Application No: M/104/25/DOC
Site Address: Former Poultry Farm land West of Yapton Road Middleton-on-sea PO22 6DY
Description of works: Approval of details reserved by condition imposed under M/80/19/PL relating to condition 7-surfacing works for Right of Way 160.

Thank you for your internet representation made on 11th January 2026 which has been recorded as an objection with the comments as follows:

PROPOSED ROAD MARKINGS
S278-38 AGREEMENT

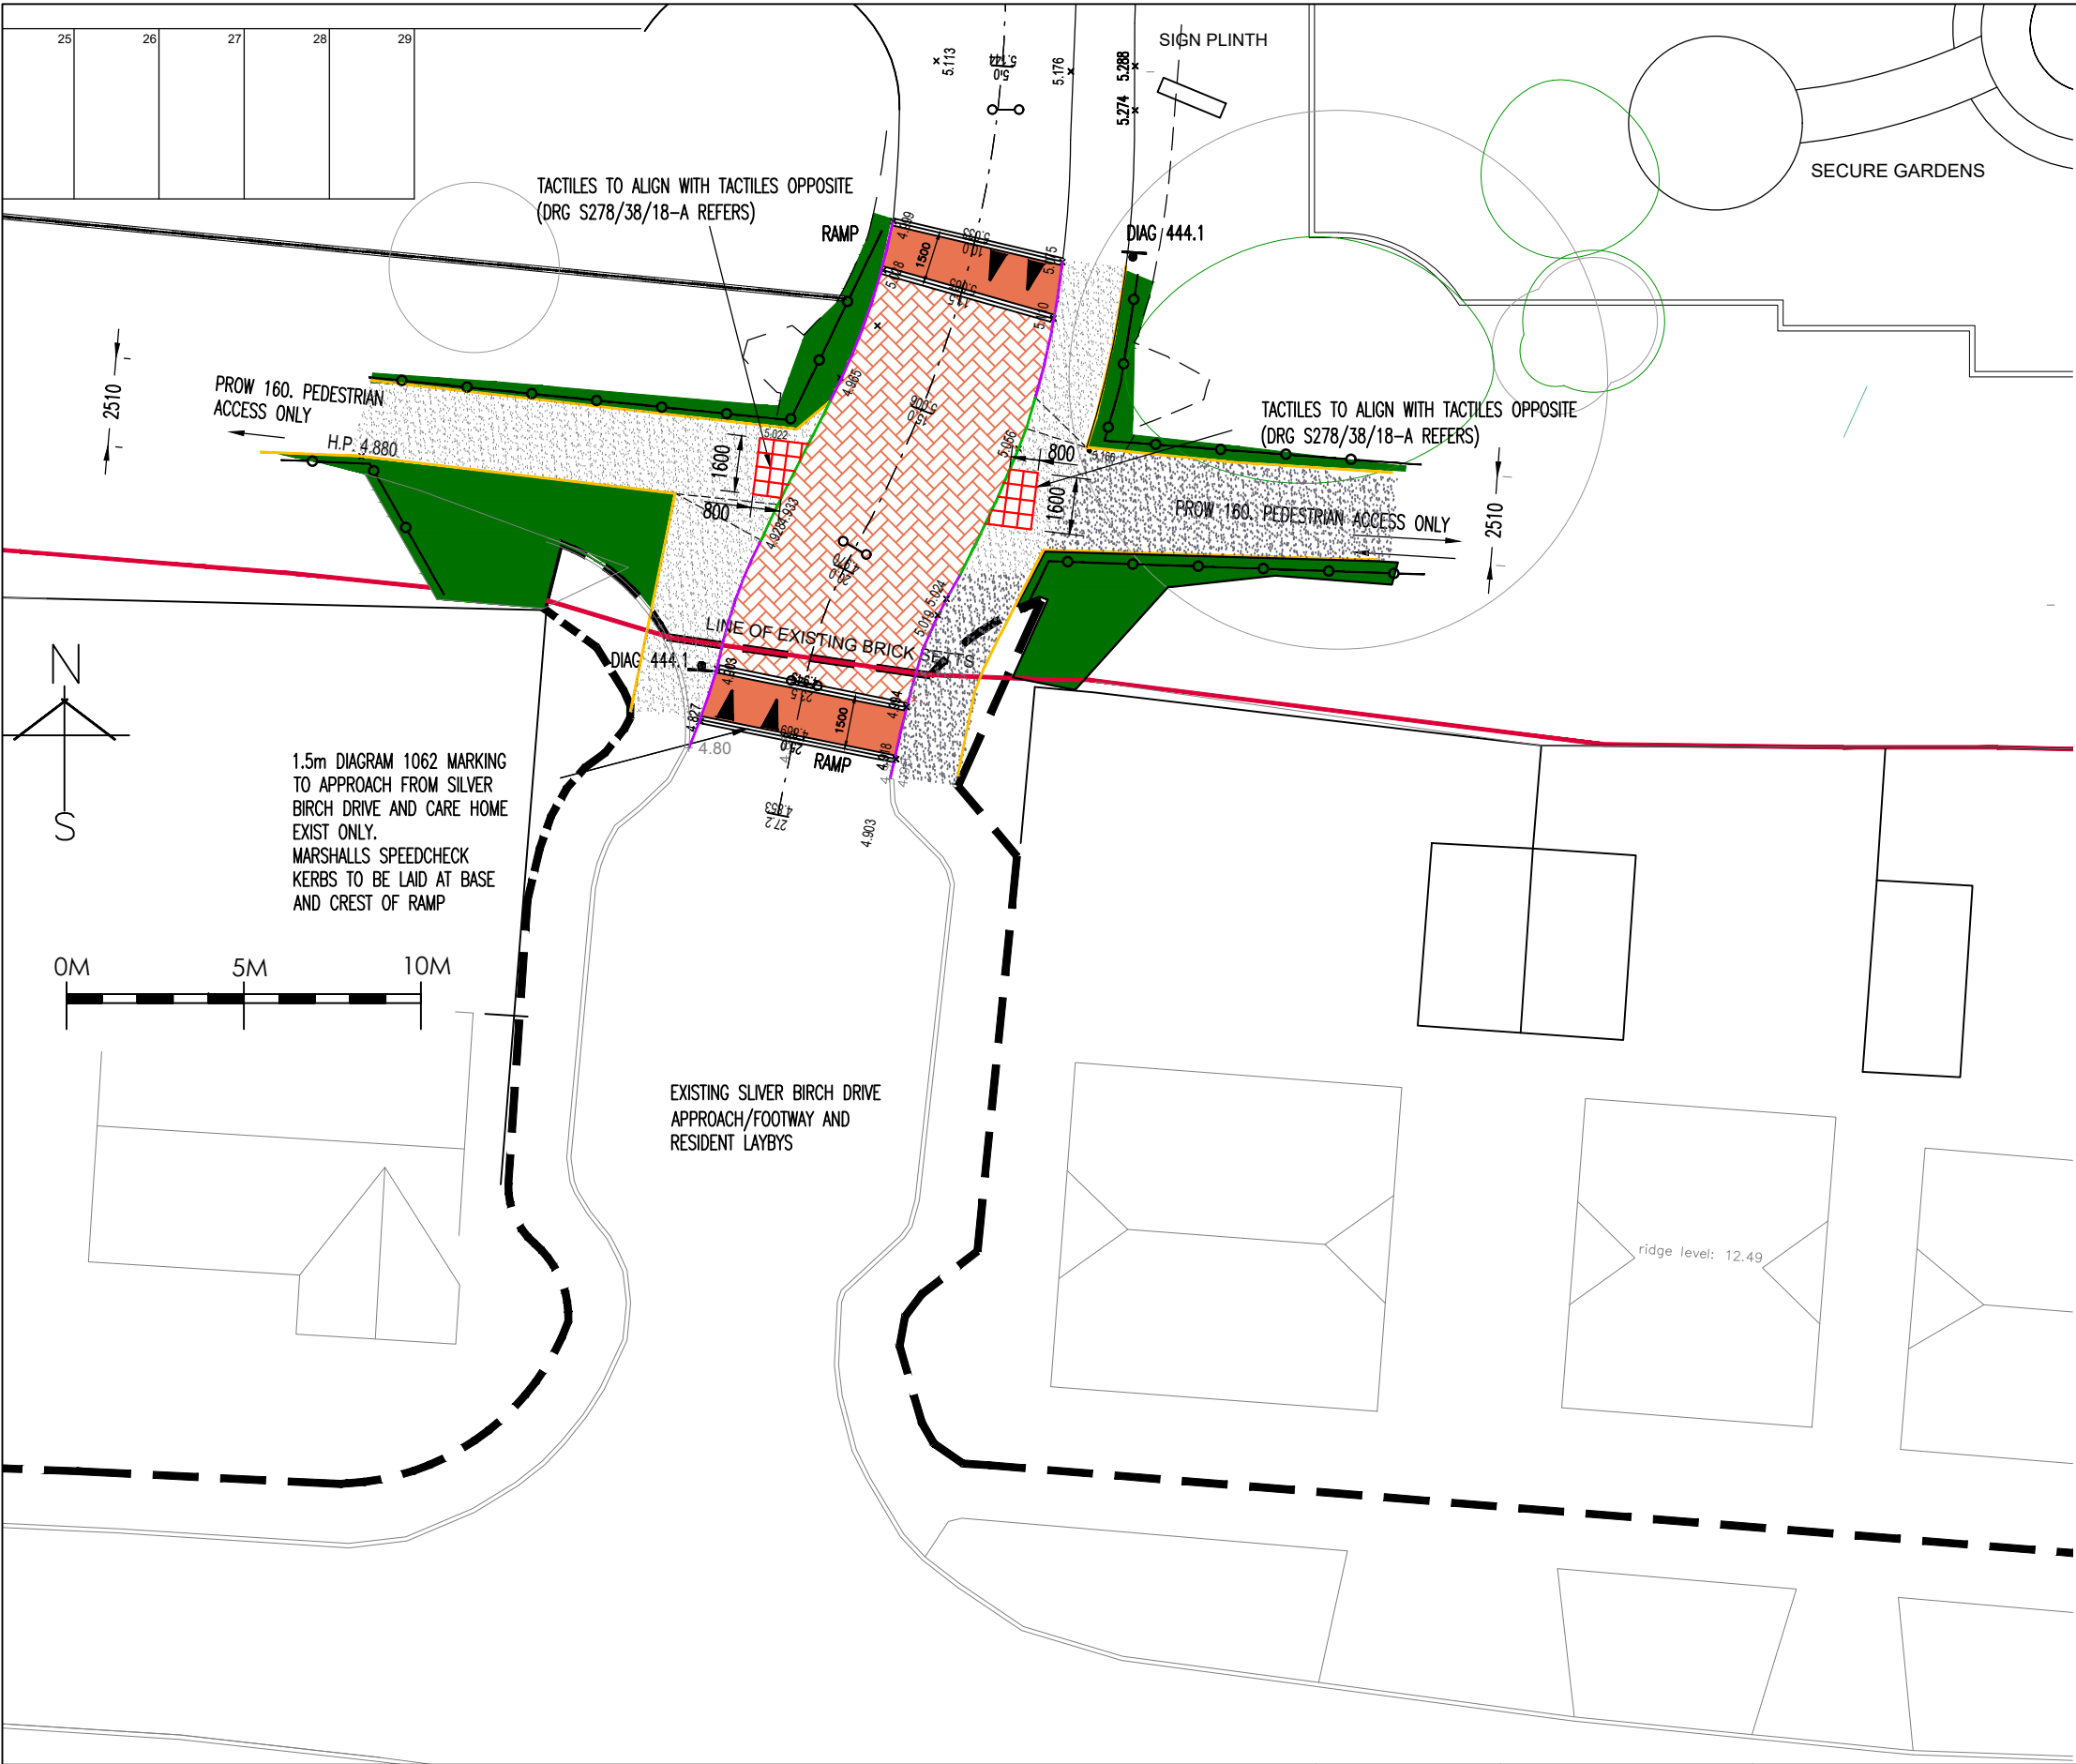
"I must emphasise that the access needs to be level and NO changes to the level should be introduced "

This planning application includes a plan to "grade" the approaches either side of the crossing. No mention is made of the surface water drainage off this grading (ie slope) nor if it is permeable paving -and even if it is, as is well known, permeable paving in circumstances such as these ceases to be permeable quite quickly due to a "blockage of the "pores" by dirt , unless industrially vacuumed twice a year, hence water run off down the " grading"will cause a muddy puddle area and either end of the grading , which is undesirable and unsafe on a well used public footpath.
